# TECHNICAL NOTE

To: Oxfordshire County Council – LLFA  
 Cc: Charlie Merry (DWD); Serena Page (DWD); Kerry Bidwell (Lysander); Charlie Shanks (Lysander);  
 File  
 From: EirEng Consulting Engineers  
 Date: 23/02/2022  
 Project Title: Banbury 200, Southam Road, Banbury OX16 2FW  
 Project No: 212088  
 Re: Planning Application 21/04157/F – LLFA Response

Appendix B – Existing Site Plan

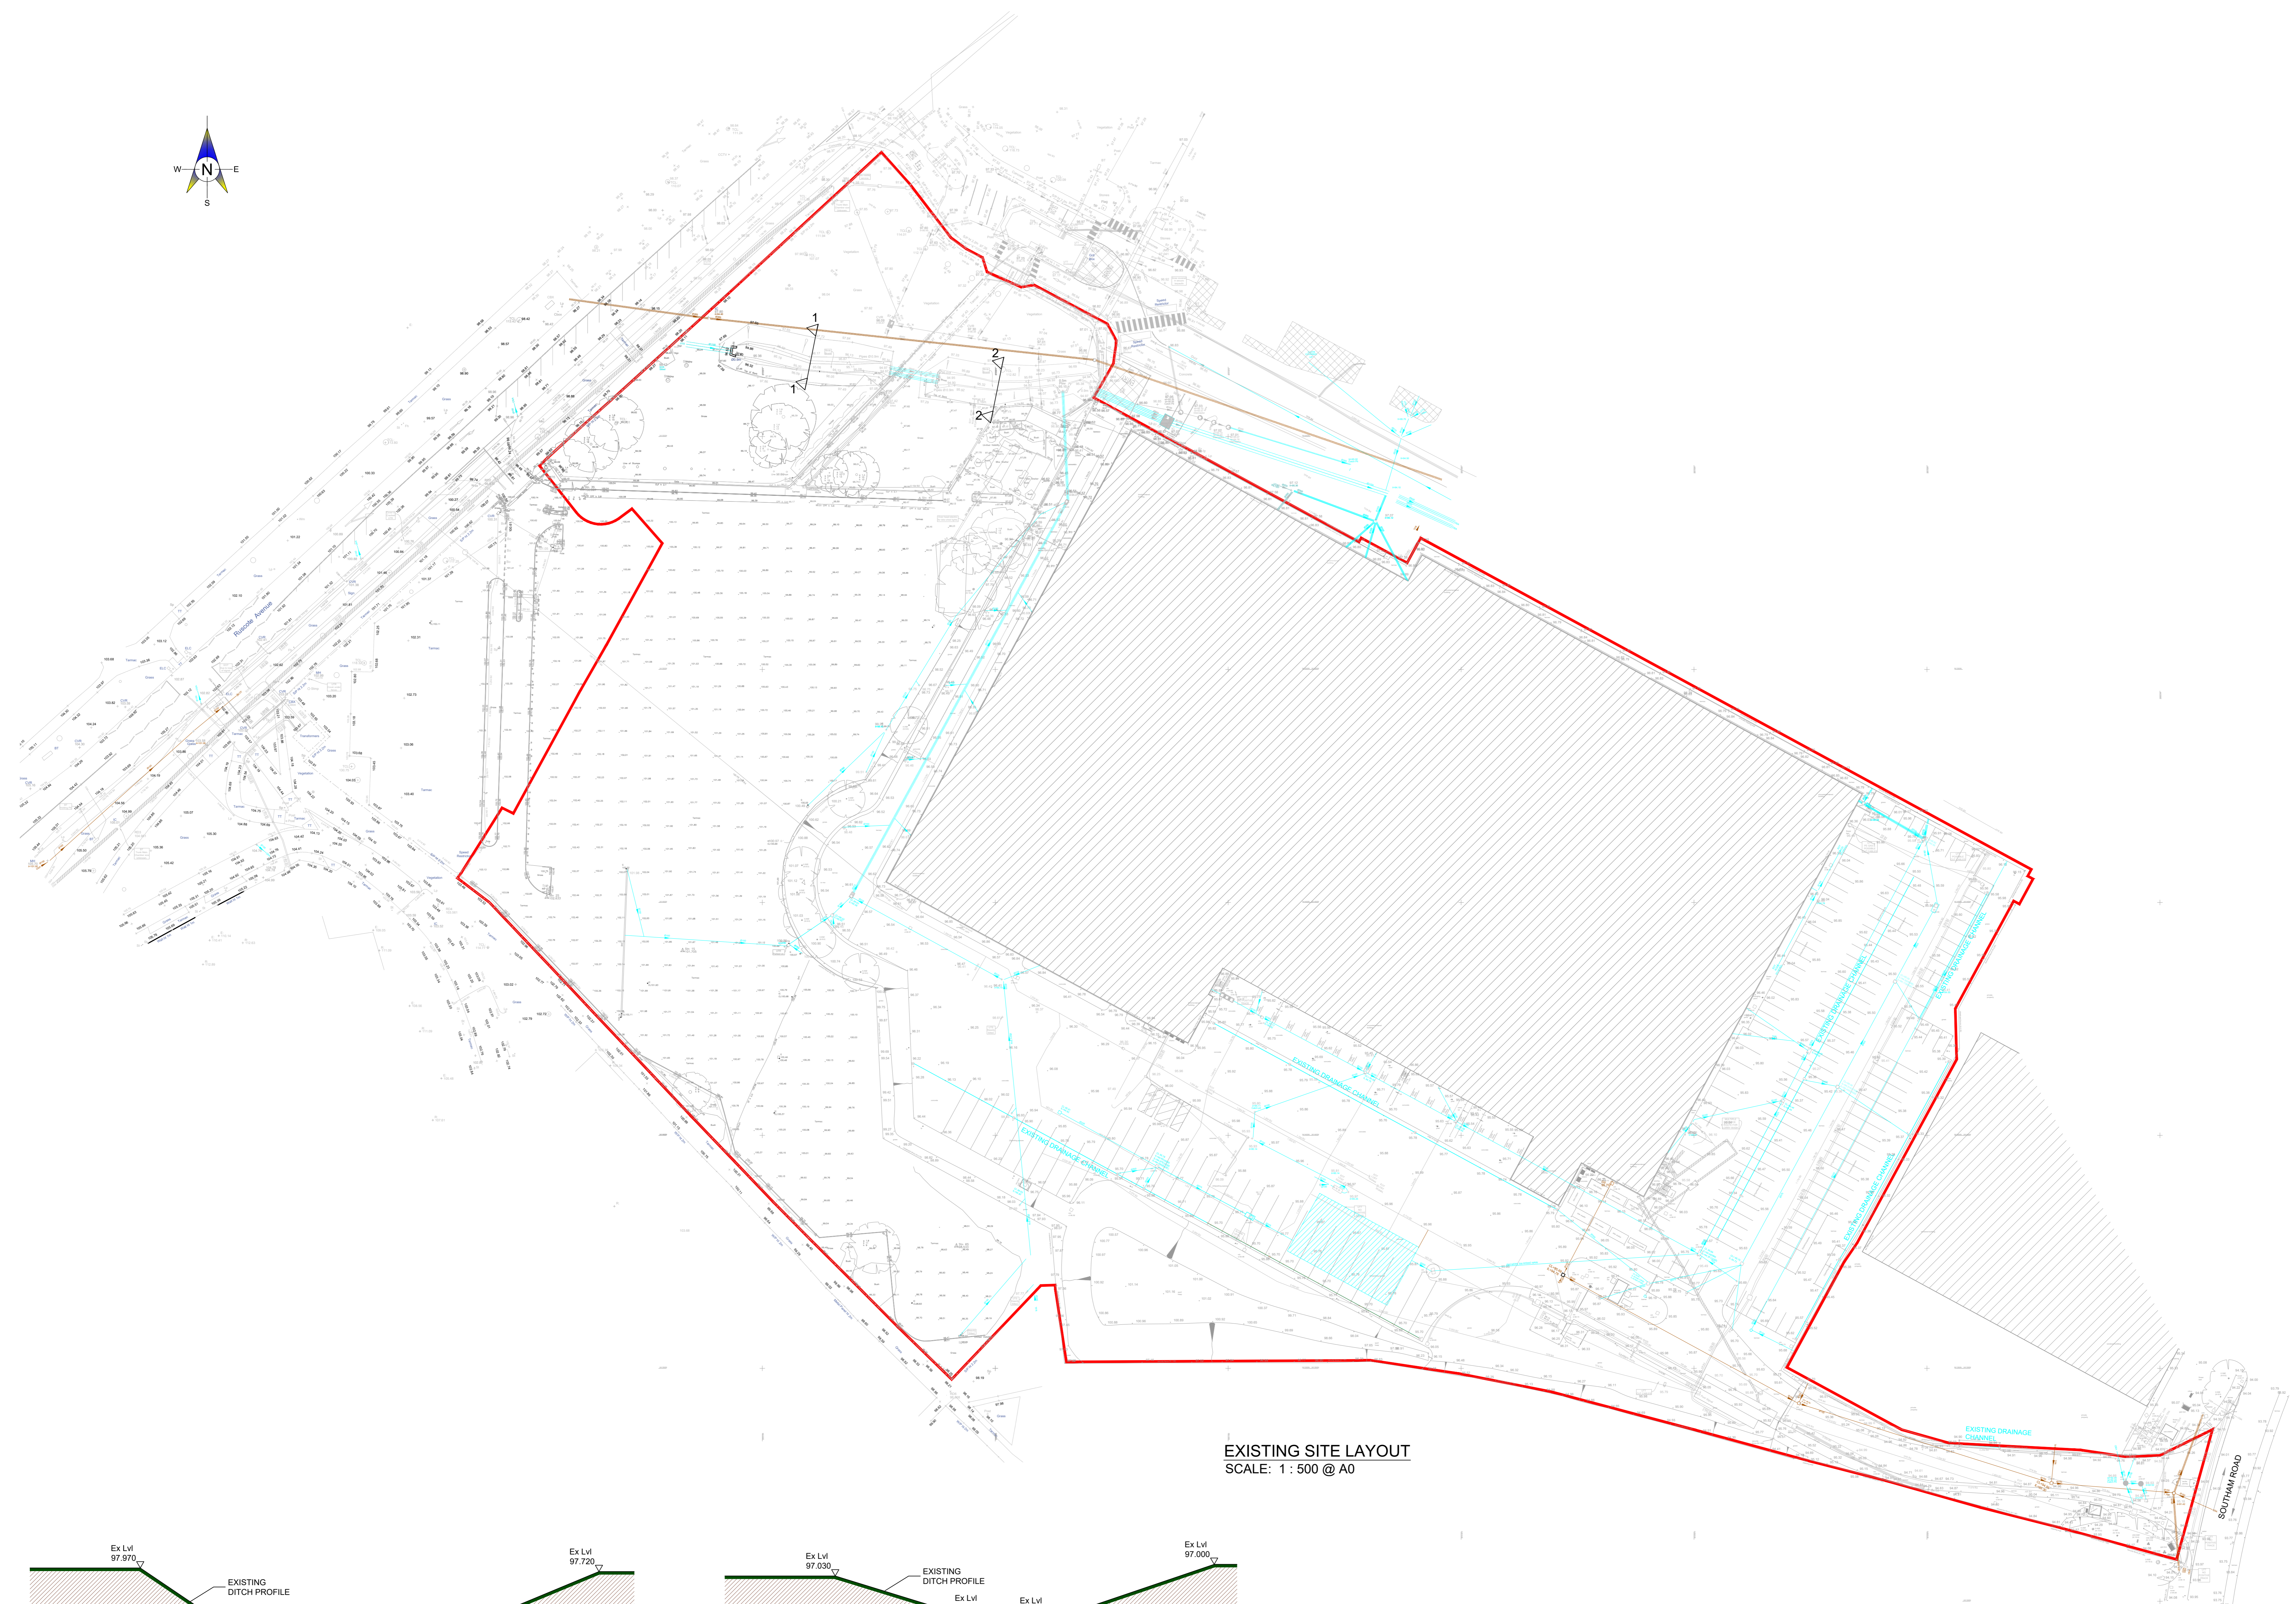
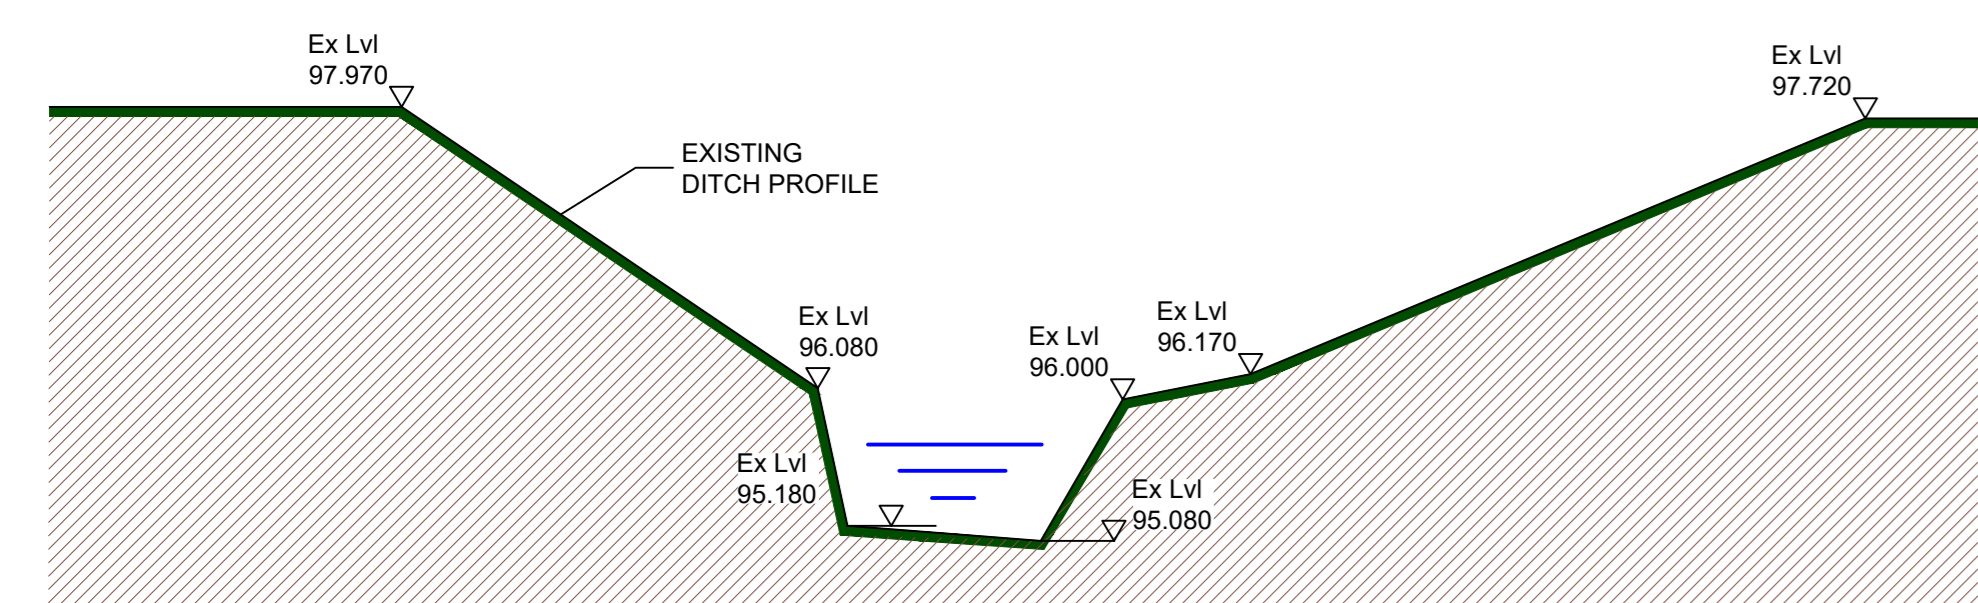
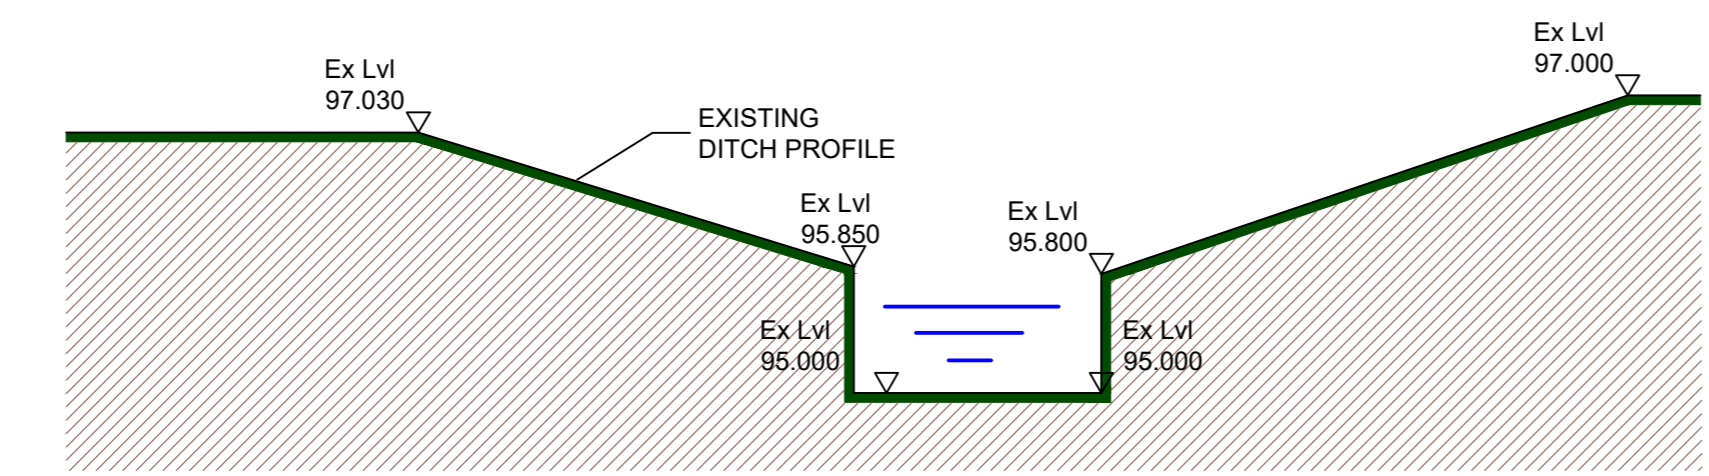
11. *The surface water drainage plan do not show the ditch details and ditch outline which the existing and proposed surface water will be connecting to.*  
The extent of the existing ditch has now been added to all drawings for clarity.

13. *Capacity of the ditch needs to be confirmed in order to ensure additional proposed surface water network can connect without causing flooding issues.*  
Refer to previous email correspondence dated 7<sup>th</sup> February 2022 and 11<sup>th</sup> February 2022, which has been included in Appendix D for completeness. These responses included details on the incoming and outgoing pipe full capacities of the ditch (based on currently available level and diameter information), together with details of all known incoming pipe capacities to the existing ditch.

The ditch has also been assessed and it seems reasonable it has been designed to attenuate the incoming flows prior to discharge from the site. We have provided a revised existing site plan with sections through the ditch which shows there is a significant element of local storage. With the reduction in flows into the ditch being reduced by as much as 95%, there will be greater storage availability prior to discharge from the site. The outgoing flows from the ditch are then conveyed by a culverted system beyond the site boundary for several kilometres downstream before it discharges to the River Cherwell.

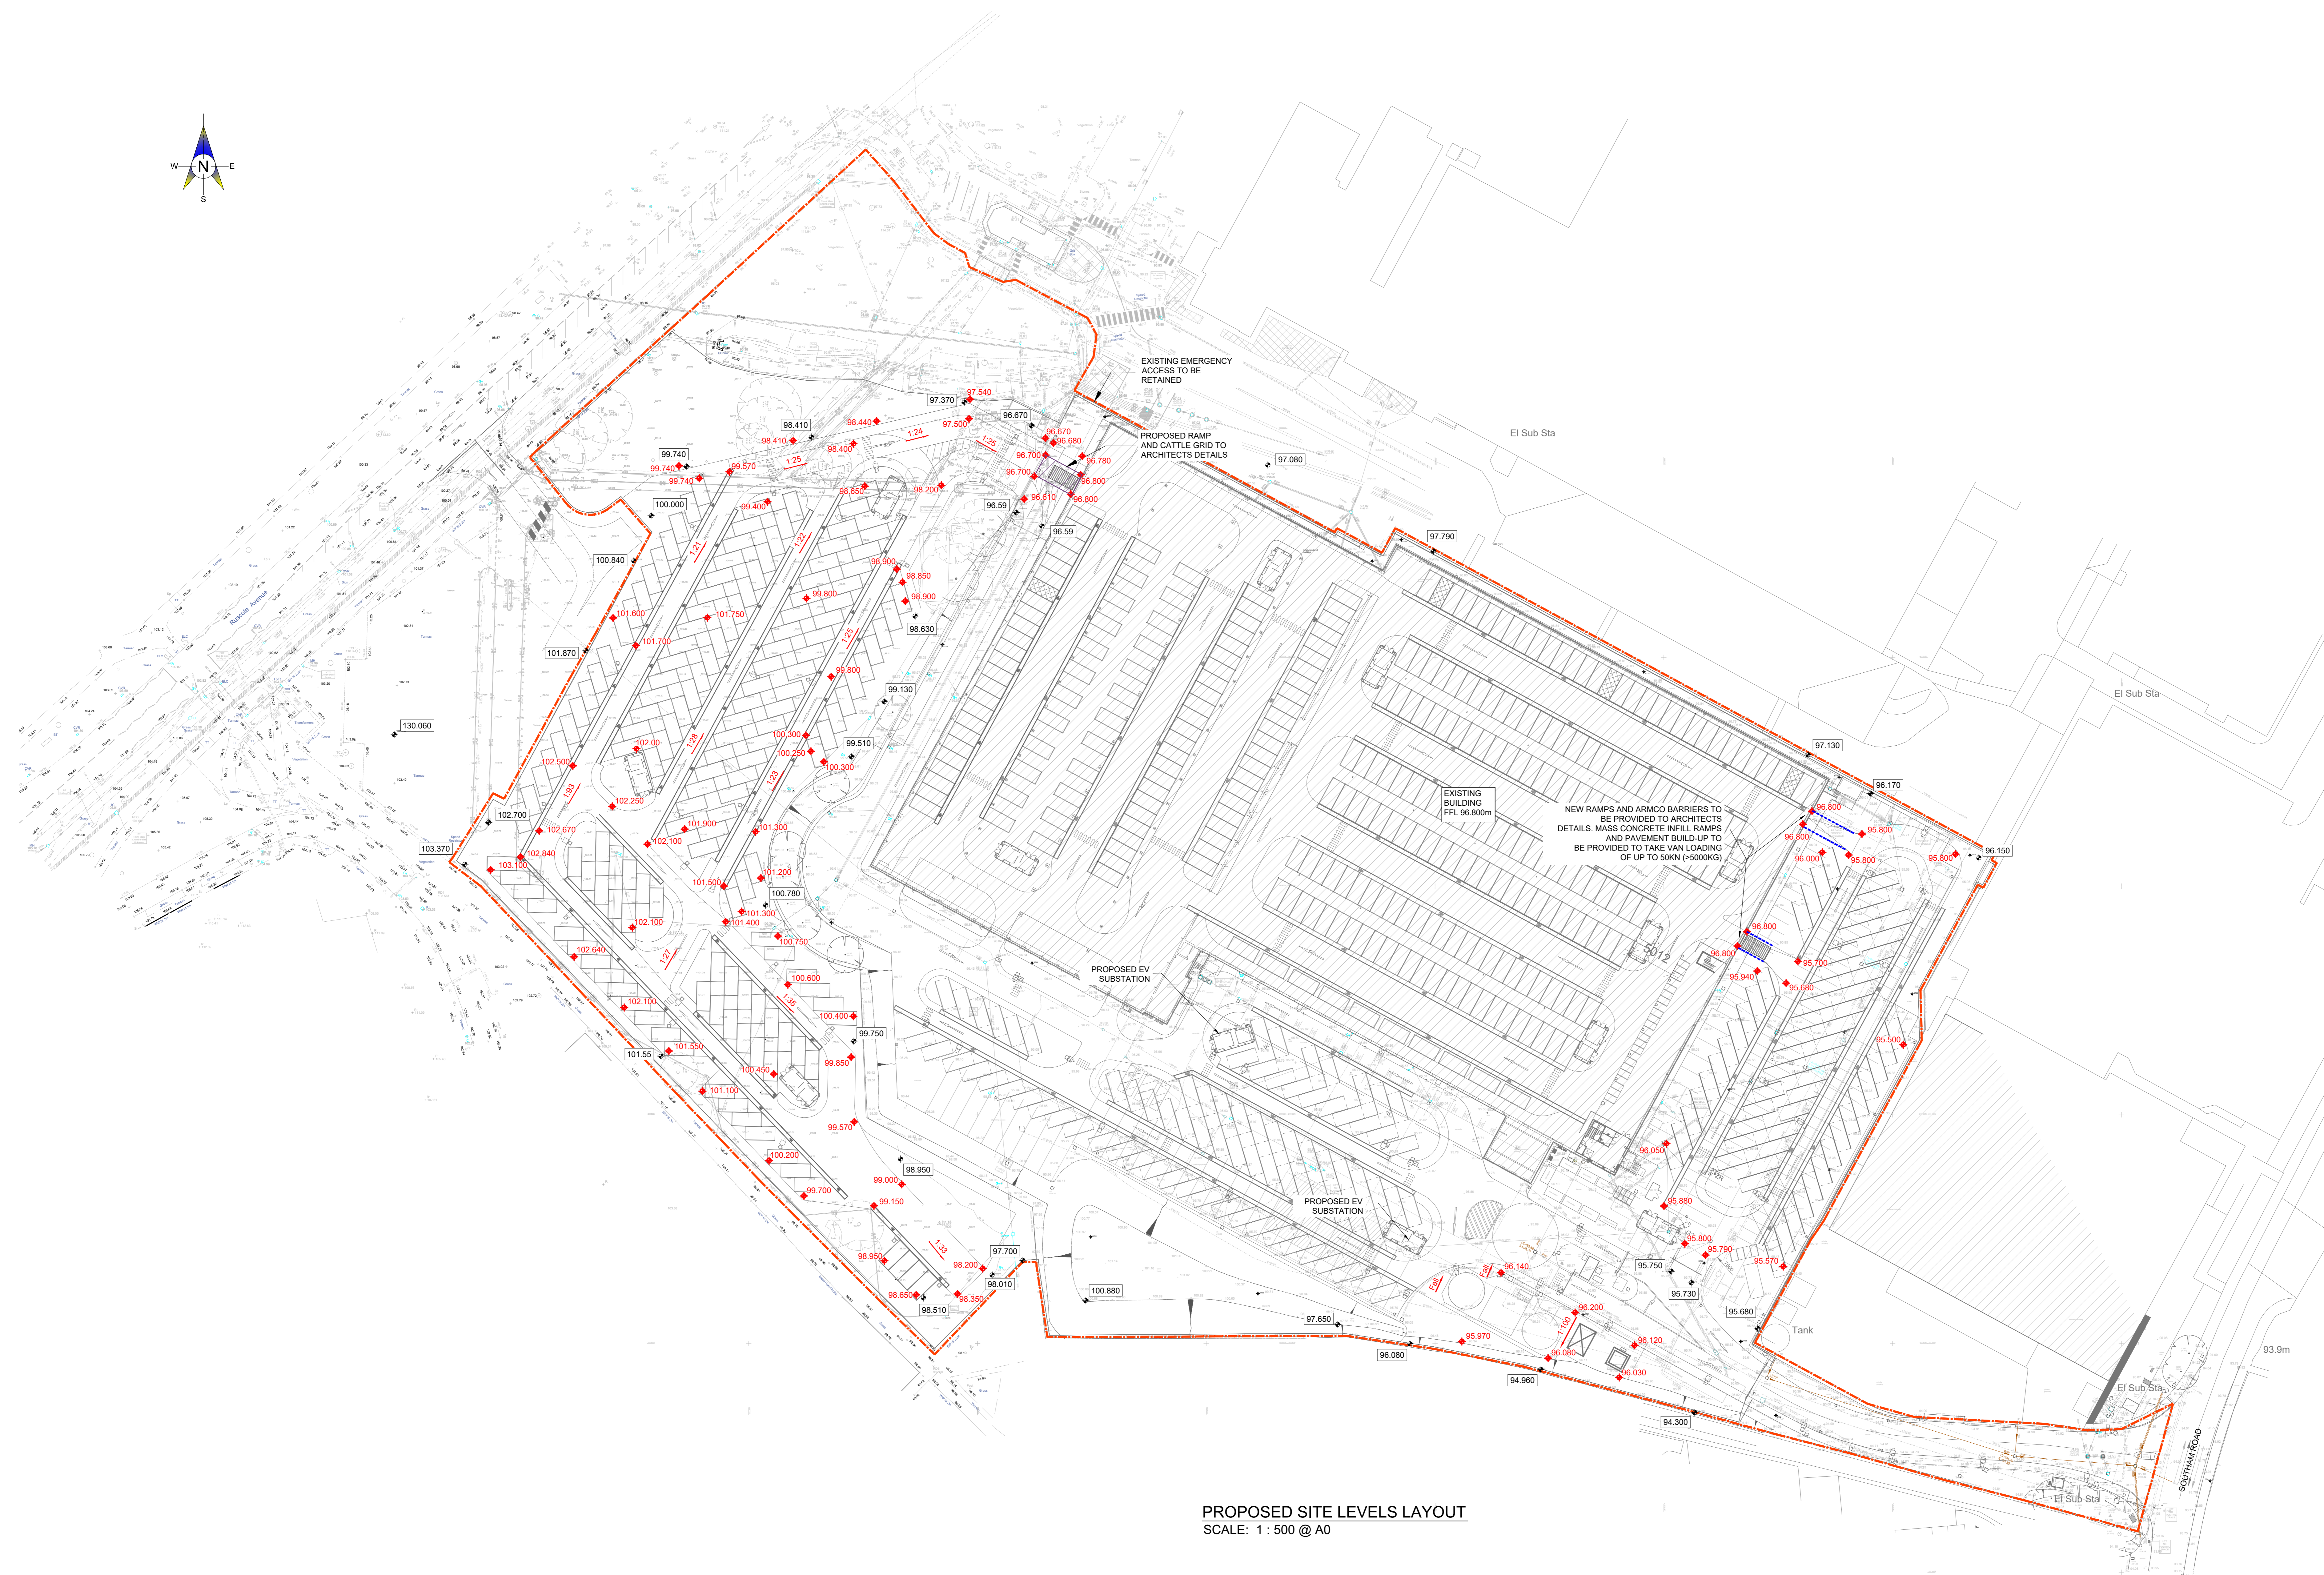
10. *Pipe gradients to be shown on the surface water drainage drawing.*  
Pipe gradients of proposed drainage were previously included on drawing 212088-C002 – Proposed Drainage Layout. These have also been included on the new drawing 212088-C005 – Modelled Network Details for completeness and is provided in Appendix B.
